# Appeal Decision

**Appeal Ref: APP/C3105/W/18/3204214**

**St George's Chapel, Round Close Road, Adderbury, Oxfordshire, OX17 3EP**

- The appeal is made under section 78 of the Town and Country Planning Act 1990 against a refusal to grant planning permission.
  - The appeal is made by Mr Tim Catling against the decision of Cherwell District Council.
  - The application Ref 17/02131/F, dated 13 October 2017, was refused by notice dated 8 January 2018.
  - The development proposed is demolition of existing chapel and erection of 1 dwelling.
-

Drawing Title
Proposed Layout

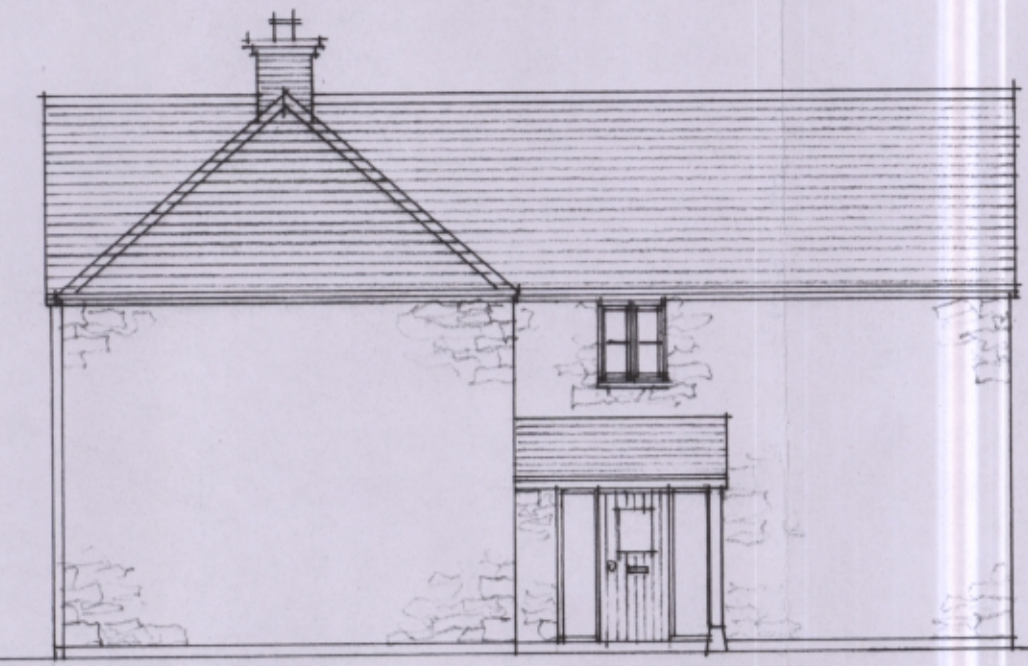
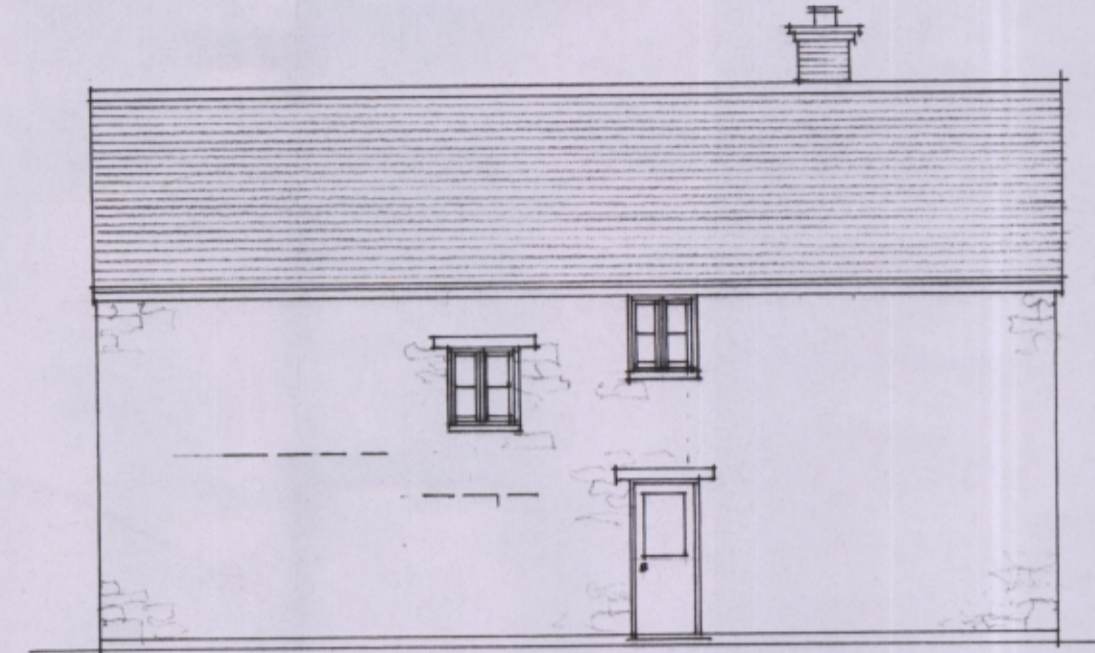
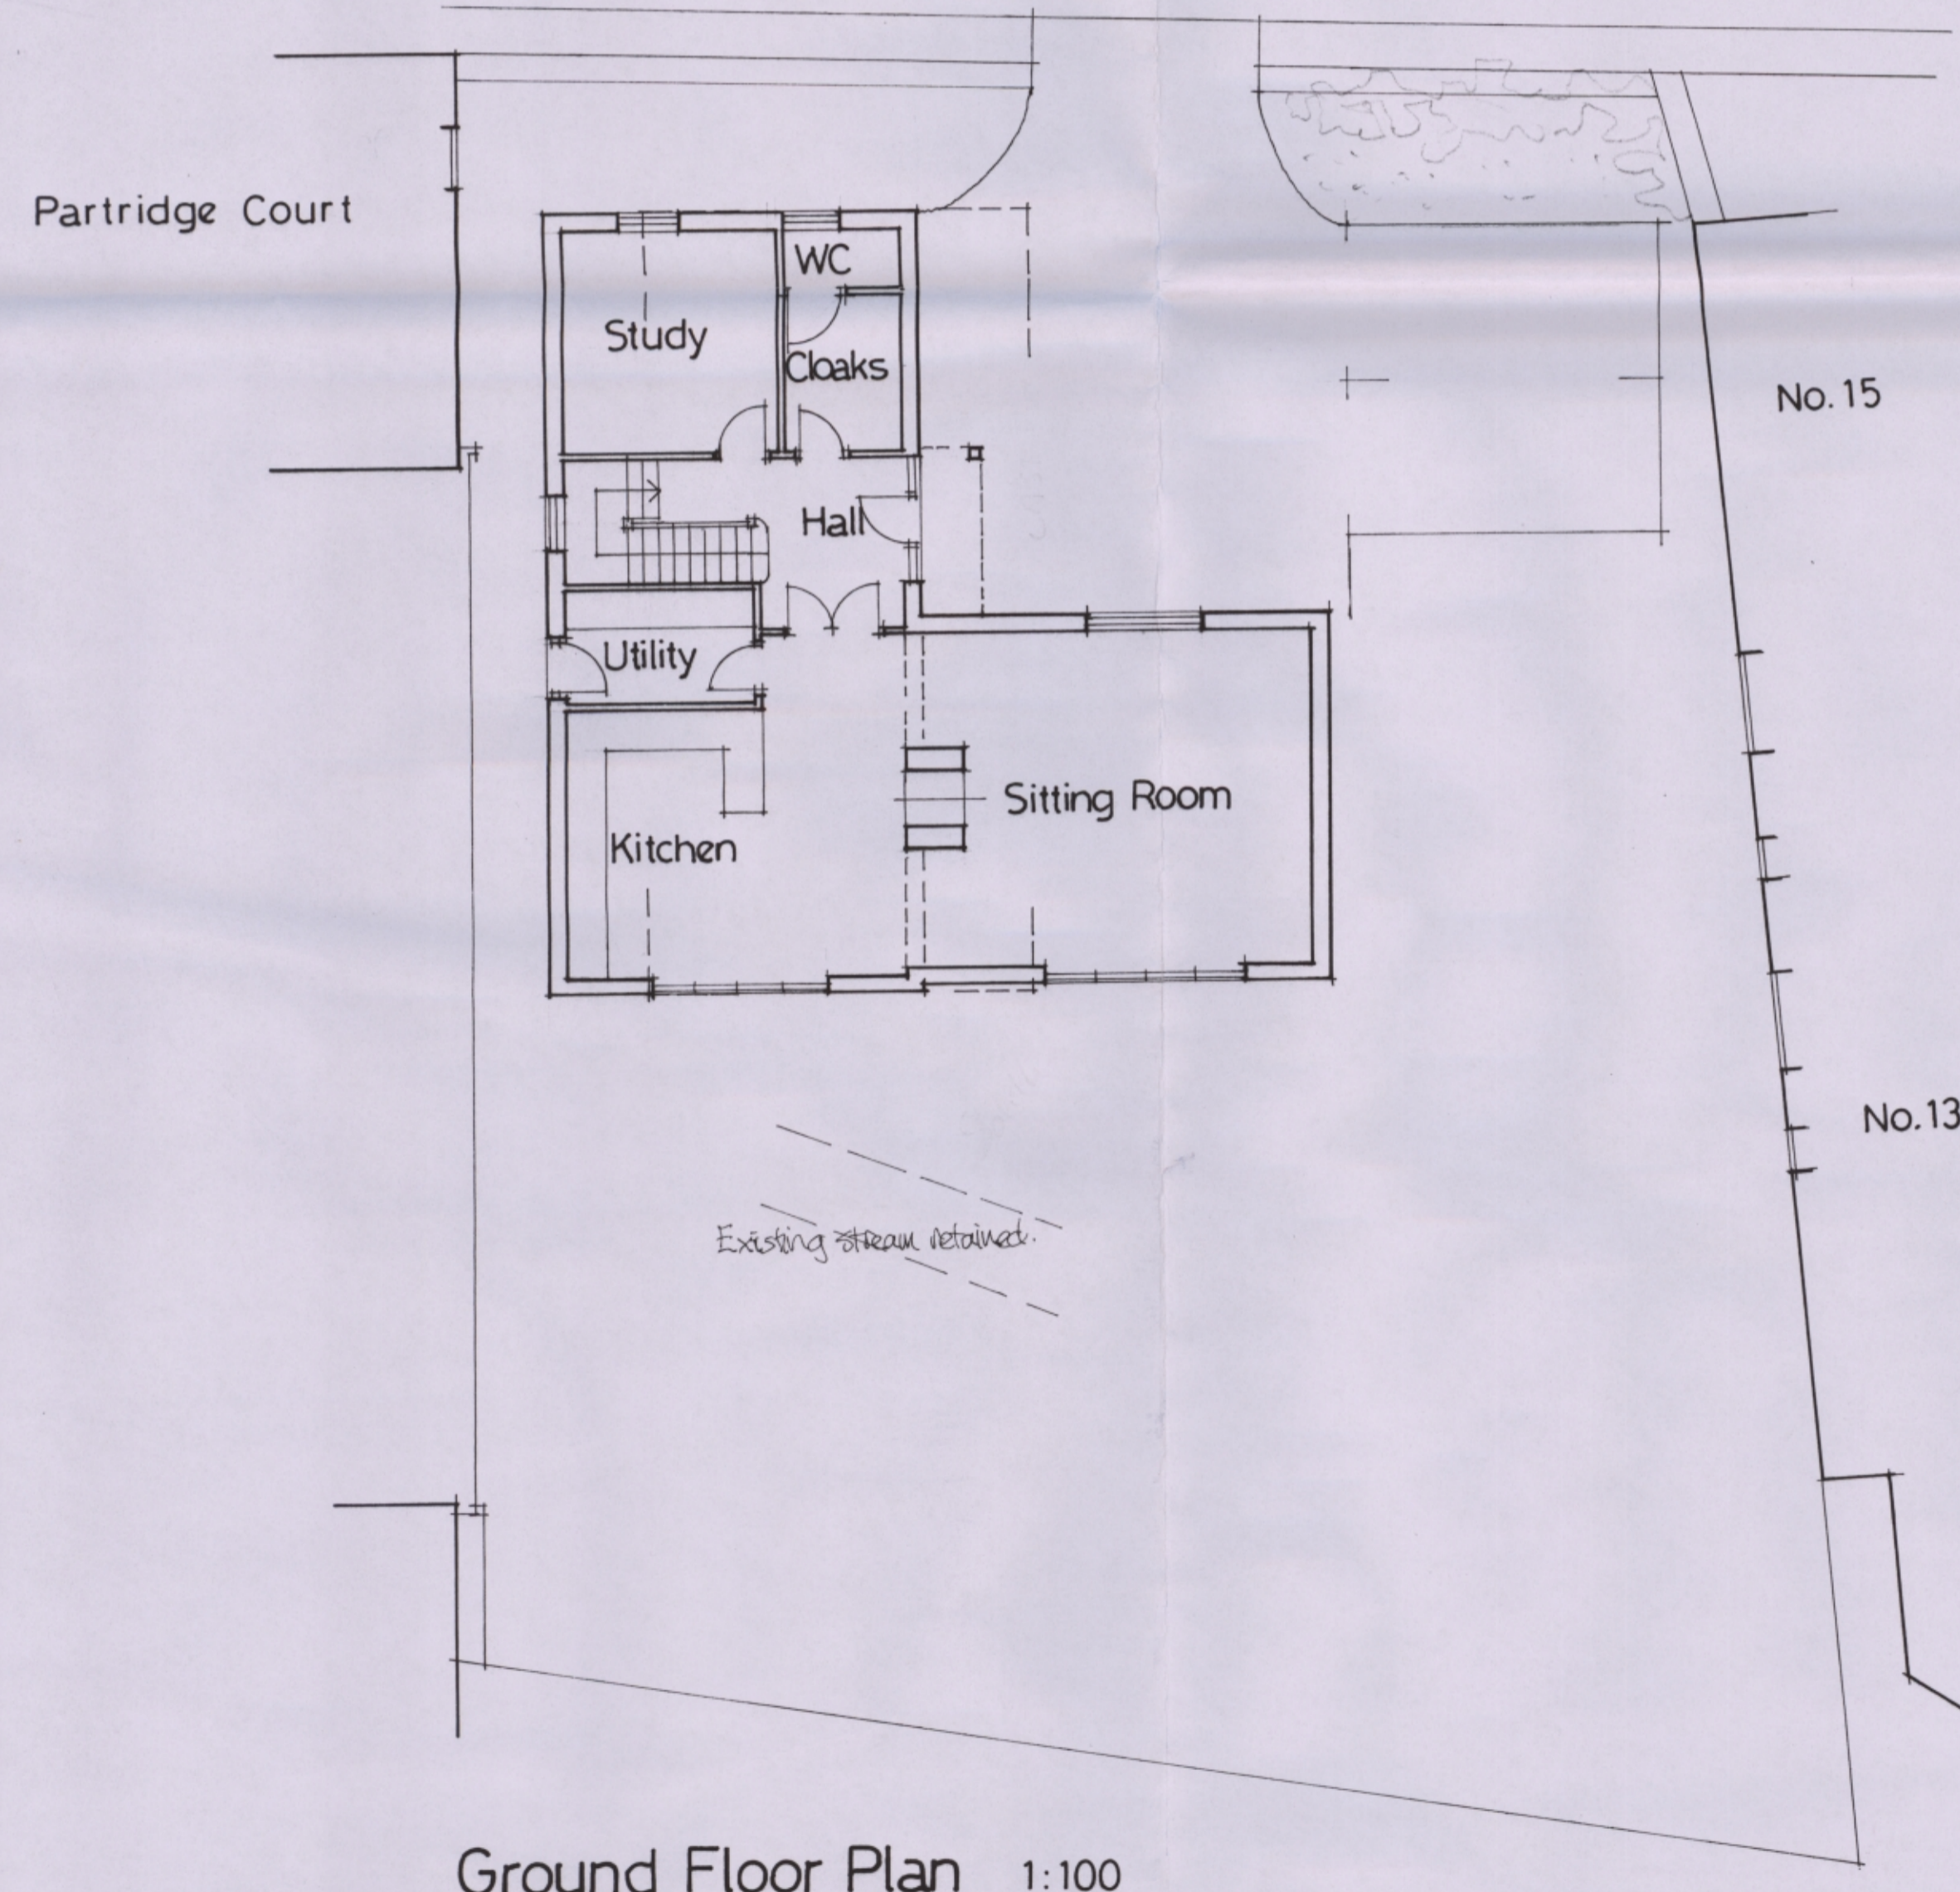
6. The proposal would introduce a detached dwelling to replace the chapel building. It would be faced in natural stone and would present a gable end to the highway in a similar form to the existing chapel. However, the building would have an 'L'-shaped footprint and its east facing projection would have a hipped roof.

7. The projection would be wider than the width of the forward projecting gable and its ridge height would be the same as the rest of the roof. Whilst it would be set back from the front of the property, due to its width and height, it would form a significant proportion of the overall mass of the building. In doing this, the projection would not be a subordinate component of the built form. Instead, it would combine with the principal gable end to create a large and imposing building when viewed from the highway.

8. There are examples of side projecting wings on historic buildings close to the appeal site. However, where they exist, they are generally narrower than the appeal proposal and therefore have a more subservient relationship to the mass of the principal buildings. Due to the width and height of the east facing projection, the scale and mass of the proposal would fail to respond to this more traditional form of building.

10. As identified above, the appeal proposal would not replicate this arrangement. The hipped roof would not form part of a subservient wing but instead, it would have an equal status with the projecting gable. In doing so, it would be afforded undue prominence within the street scene and, consequently, would have a harmful effect on the character and appearance of the CA.

Ground Floor Plan 1:100

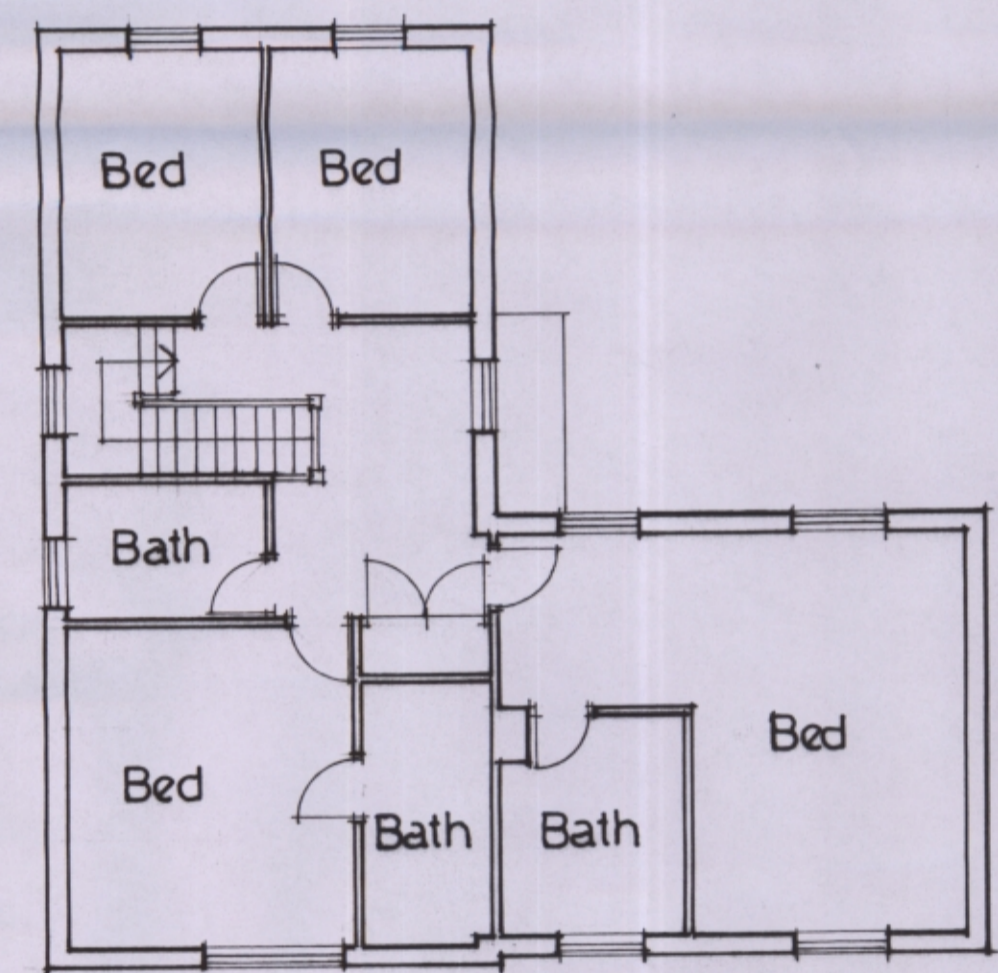
15. The proposed building would be located approximately 6.5 metres from the adjacent windows, significantly less than the dimension advised in the Council's Home Extensions and Alterations Design Guide. However, I observed on my site visit that due to the positioning of the proposed side elevation, the 2 principal windows serving each of the neighbouring houses would be off-set from the main bulk of the side wall. This would have the effect of reducing the impact on the facing windows as a meaningful outlook would still be achieved beyond the built form of the proposal. The proposal would therefore not harm the outlook from the neighbouring properties.

16. Despite this, the amenity space of the proposed dwelling would be immediately adjacent the facing windows. The proposal does not include details of any means of enclosure that would prevent future occupants standing next to these windows and achieving clear views into the rooms of the neighbouring properties. This is an existing situation, but the use of the site for residential purposes as opposed to a place of worship would see the adjacent amenity space used in a more intense manner.

19. The location of the neighbouring windows would also affect the amenity space for the proposed dwelling. Due to their location, the windows would directly overlook this space and for the same reasons identified above, this could not be resolved through the imposition of a suitably worded condition.
20. I therefore conclude that the proposal would fail to provide suitable living conditions for future occupants due to the lack of private amenity space. Consequently, the proposal would fail to accord with Saved Policy C30 of the CLP and Policy ESD15 of the LP which together, require development to
